Subject: METROWEST DCO EXAMINATION – ISSUE SPECIFIC HEARING 3 (ENVIRONMENTAL MATTERS) – ENVIRONMENT AGENCY WRITTEN RESPONSE TO AGENDA ITEM 5 (FLOOD RISK, DRAINAGE AND CONTAMINATED WATERS)

Our ref: WX/2019/133441/01-L09
Your ref: TRO40011
Date: 10 January 2021

**METROWEST DCO EXAMINATION – ISSUE SPECIFIC HEARING 3
(ENVIRONMENTAL MATTERS) – ENVIRONMENT AGENCY WRITTEN RESPONSE
TO AGENDA ITEM 5 (FLOOD RISK, DRAINAGE AND CONTAMINATED WATERS)**

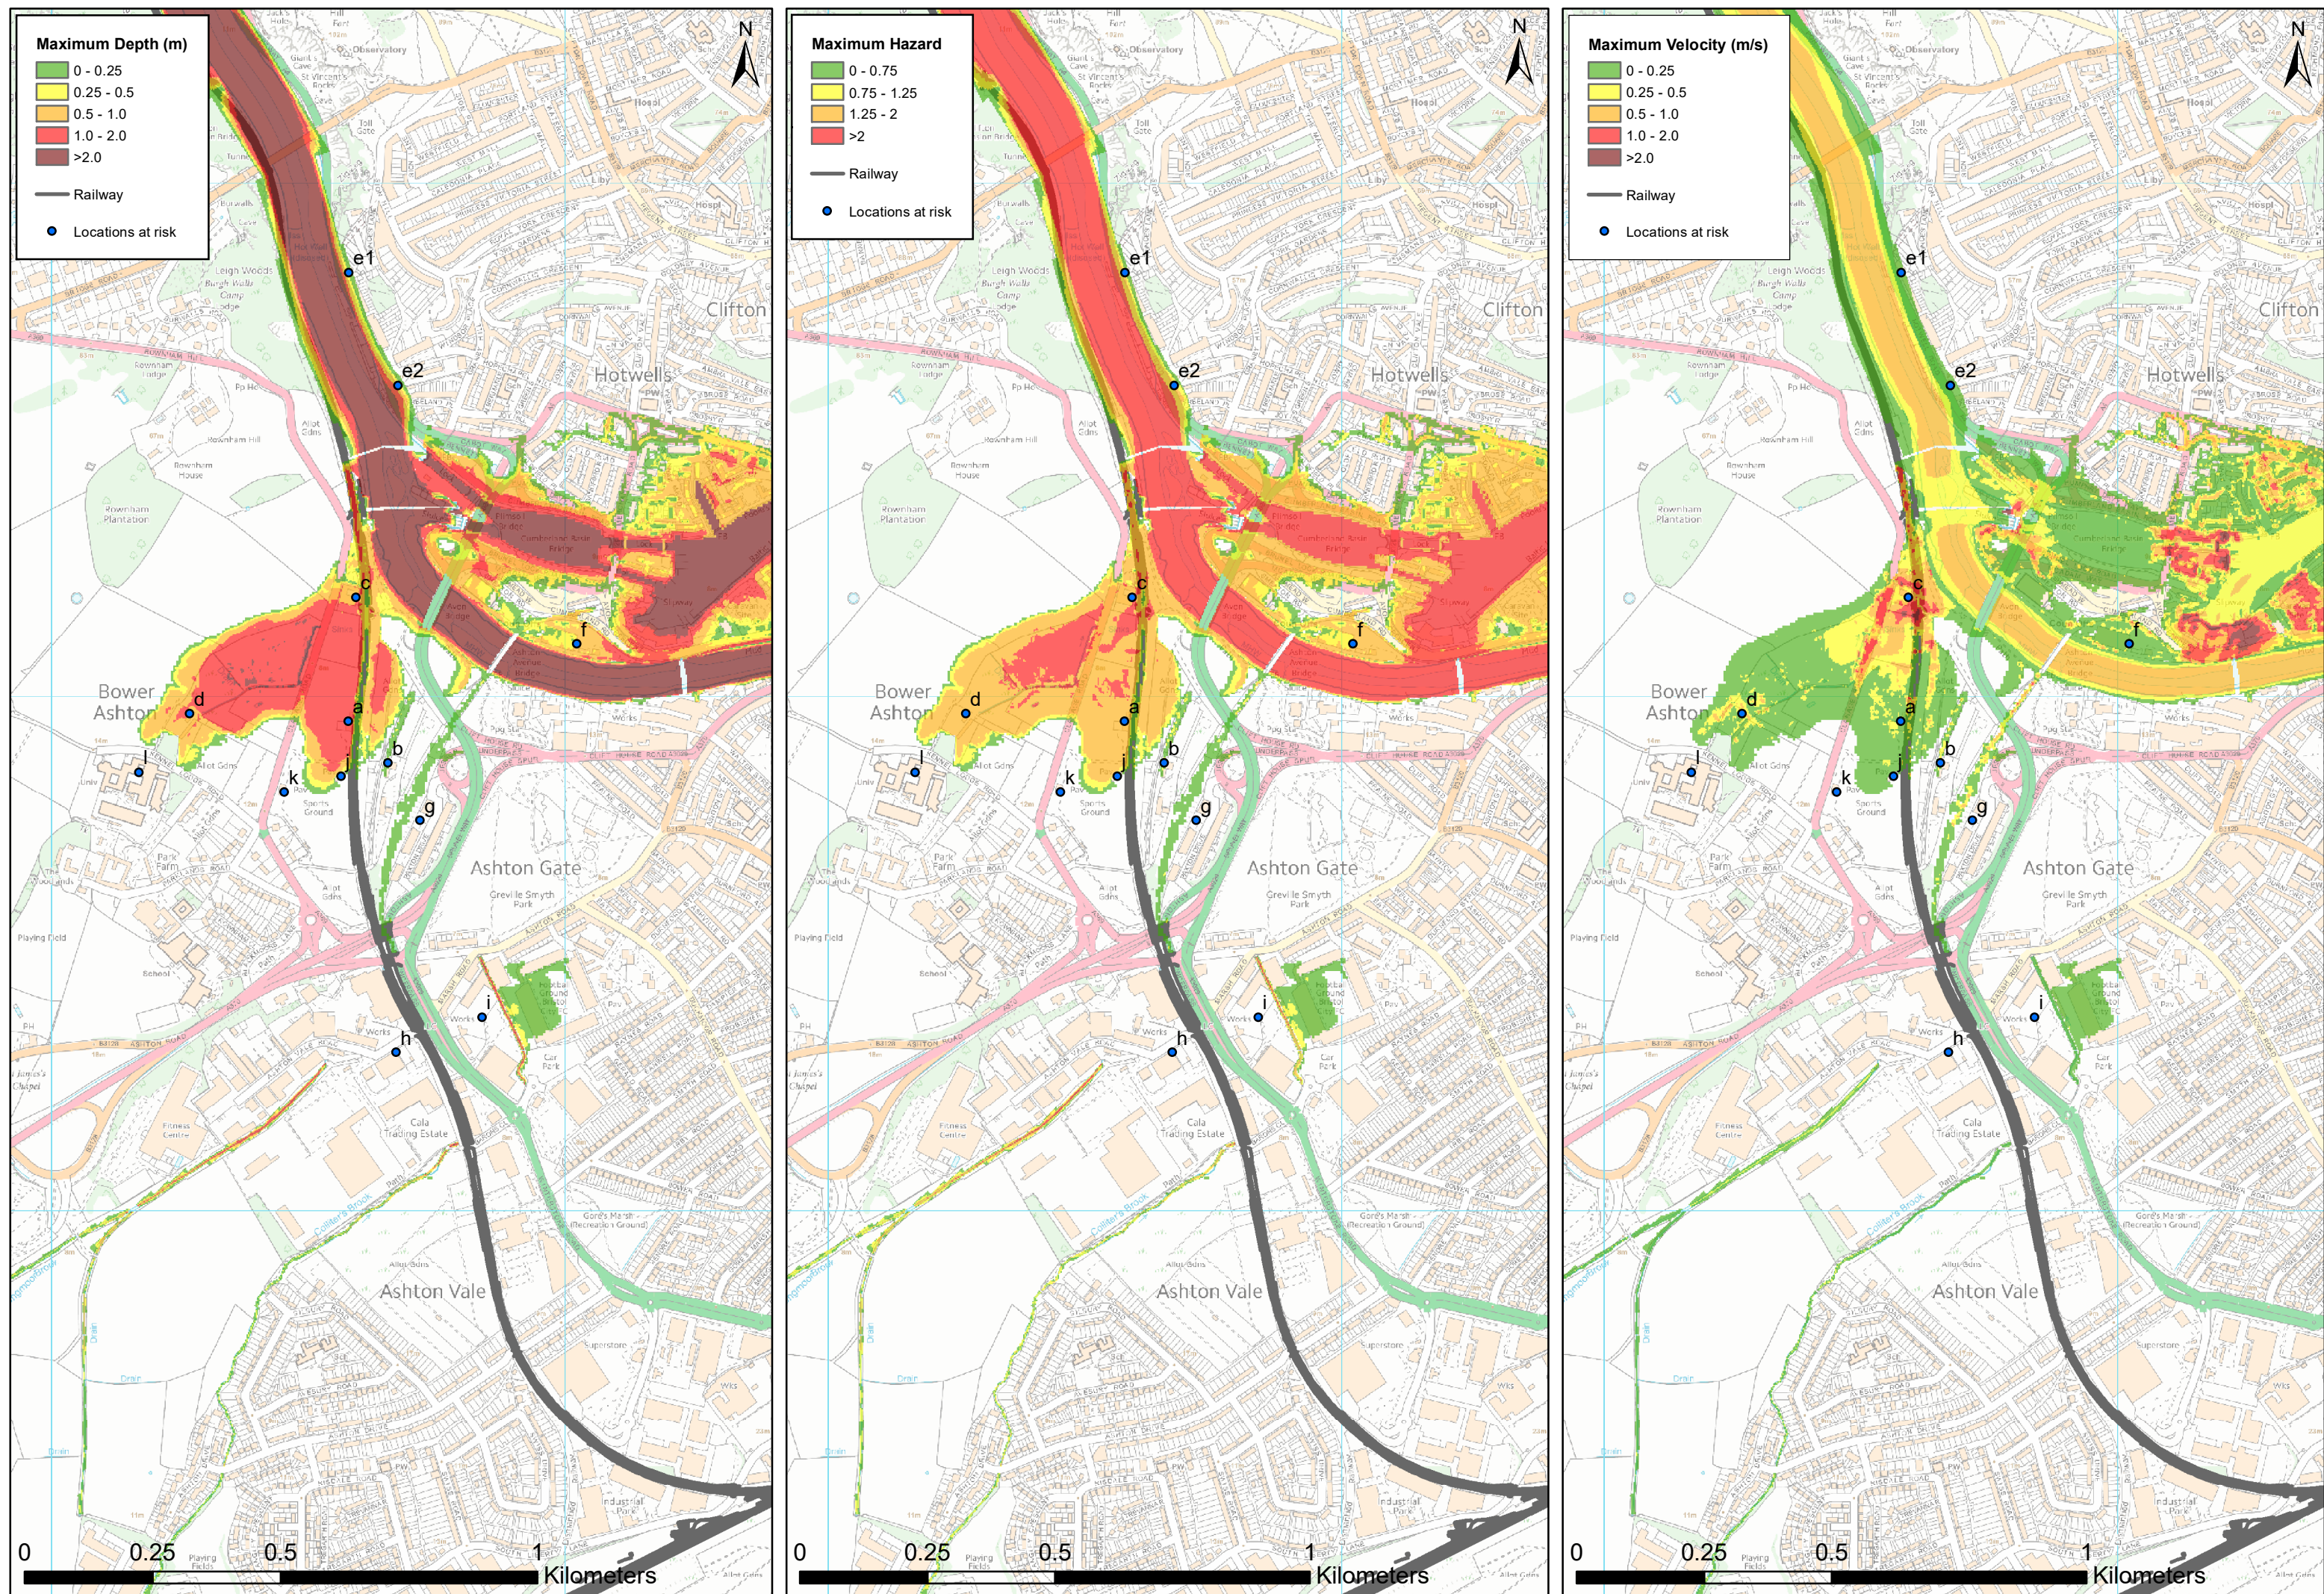
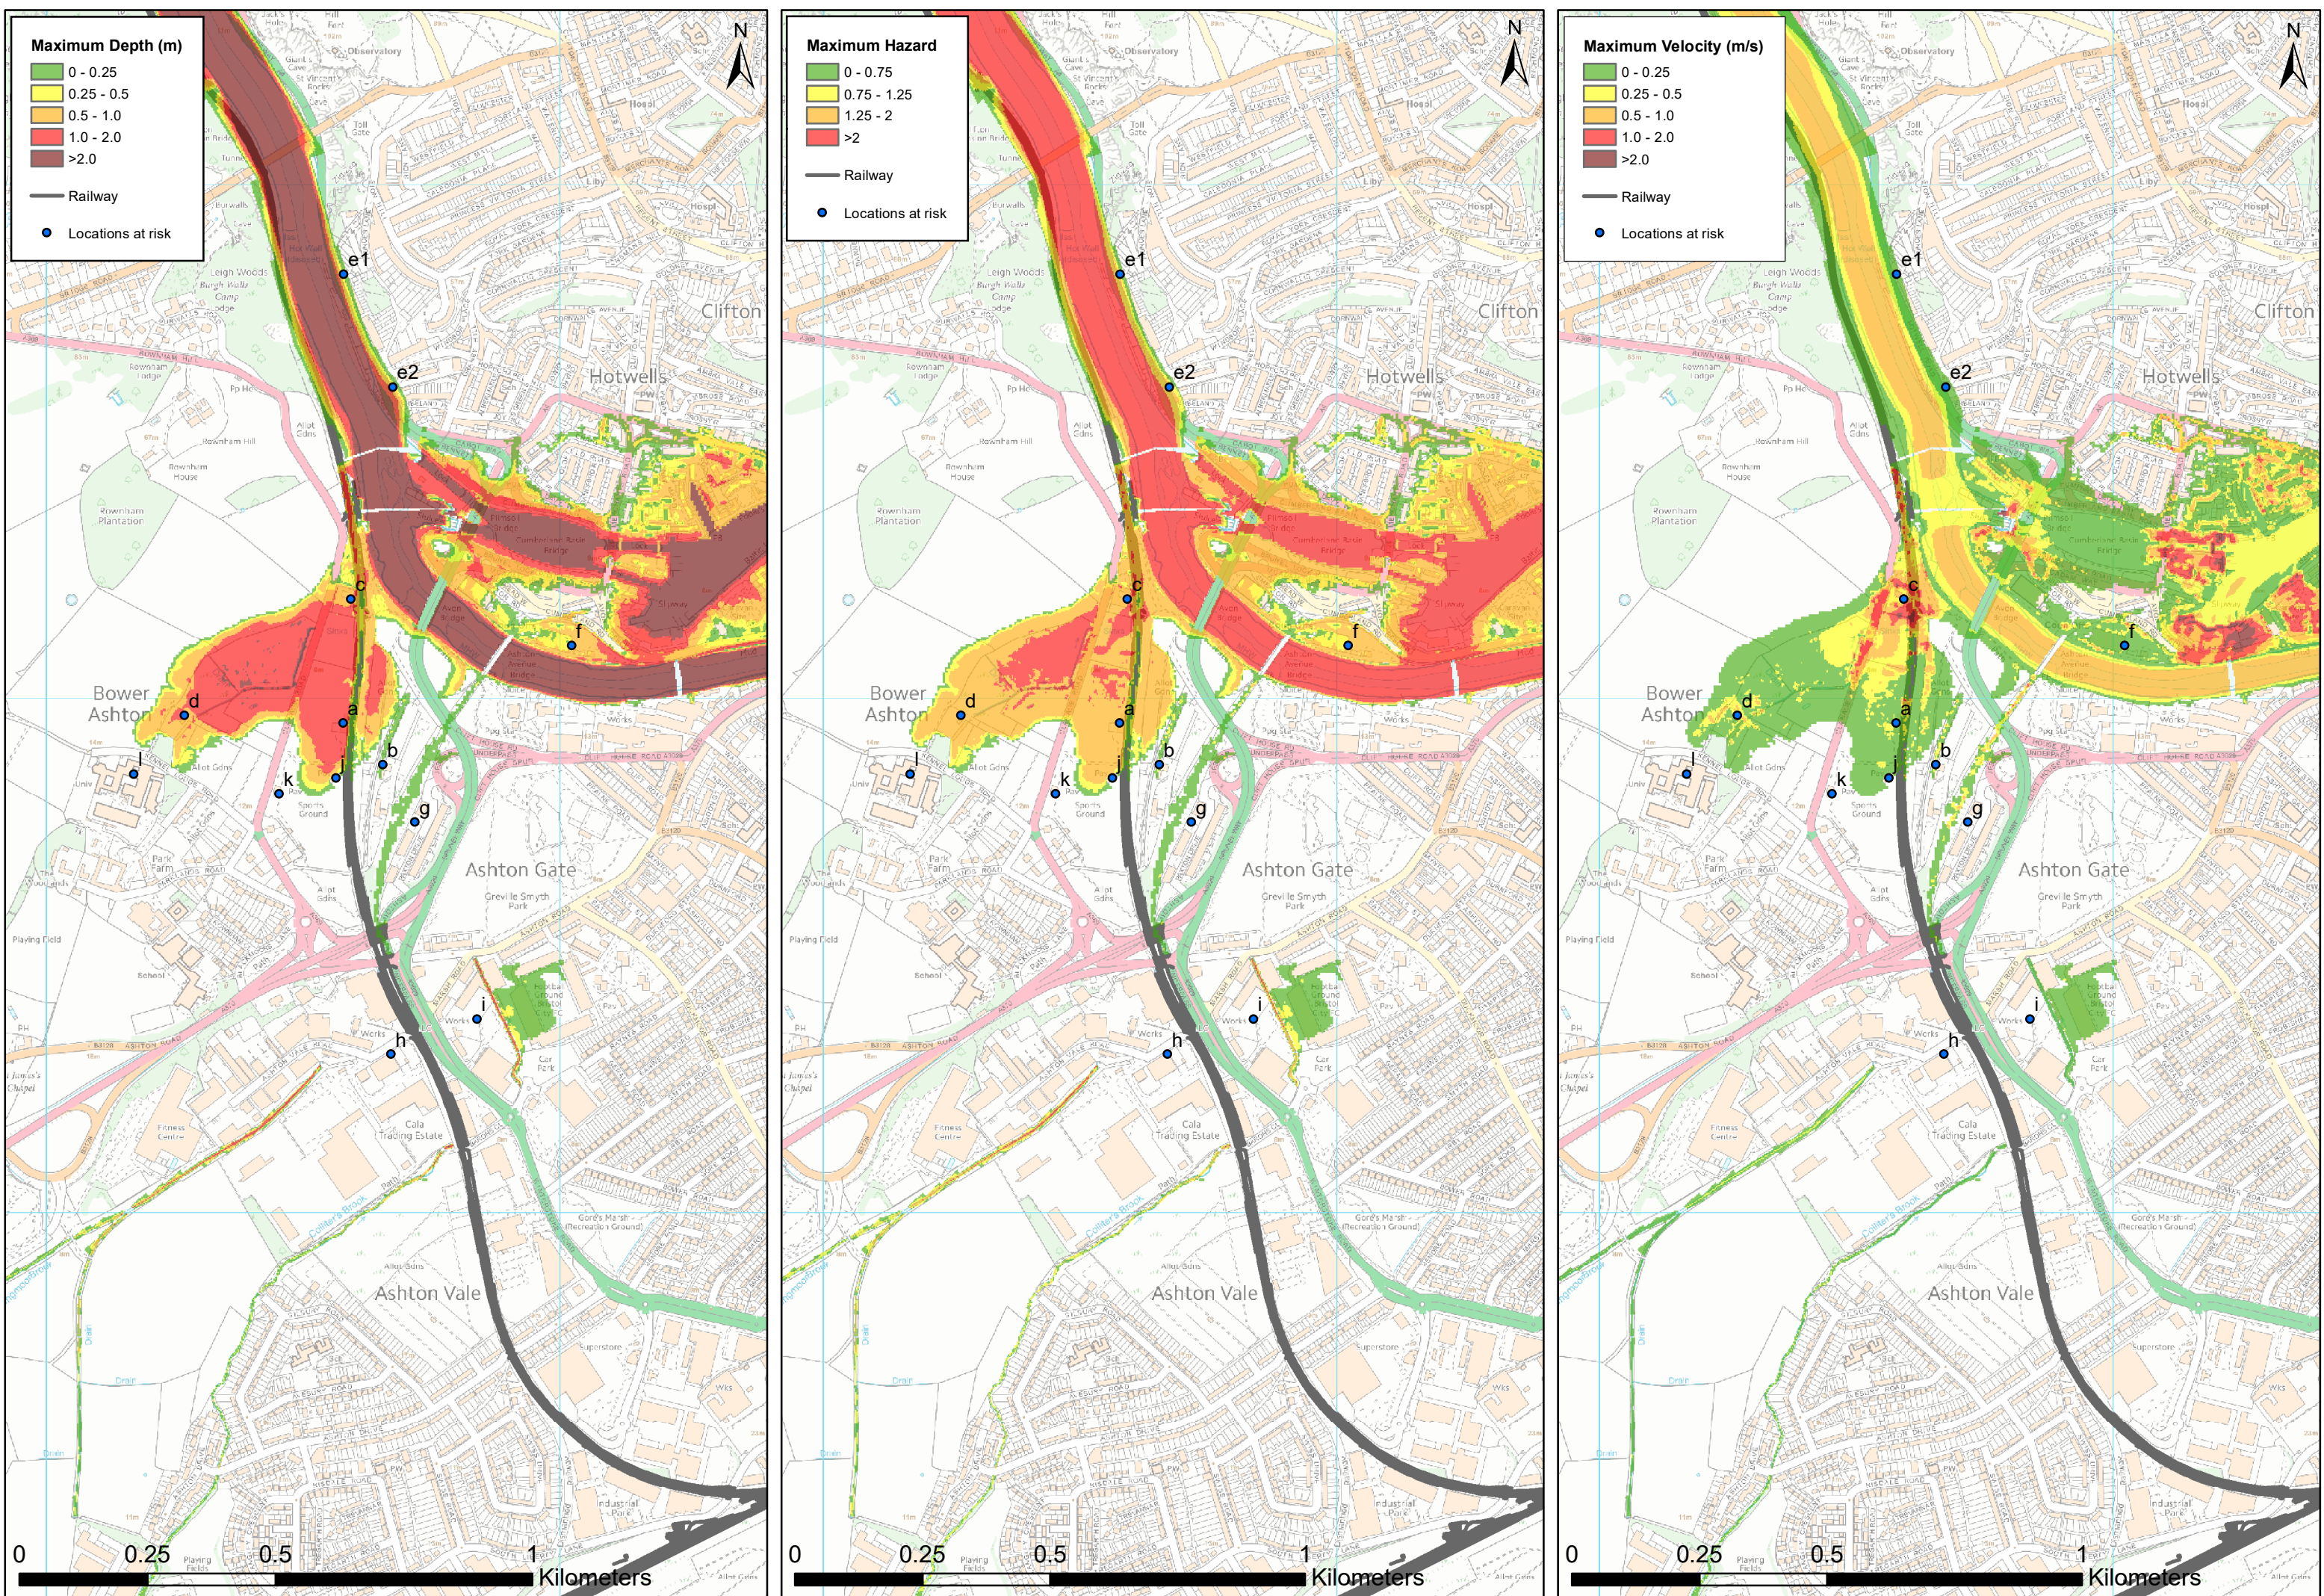
The Flood Risk Assessment (FRA) submitted in support of the proposal, has demonstrated that part of the site is in functional floodplain (Flood Zone 3b) and will, as a consequence, flood at a return period as low as 1 in 5 years at present. With the predicted impact of climate change, the frequency of flooding (and flood depth) increases to a potential 5 times a year in 2115.
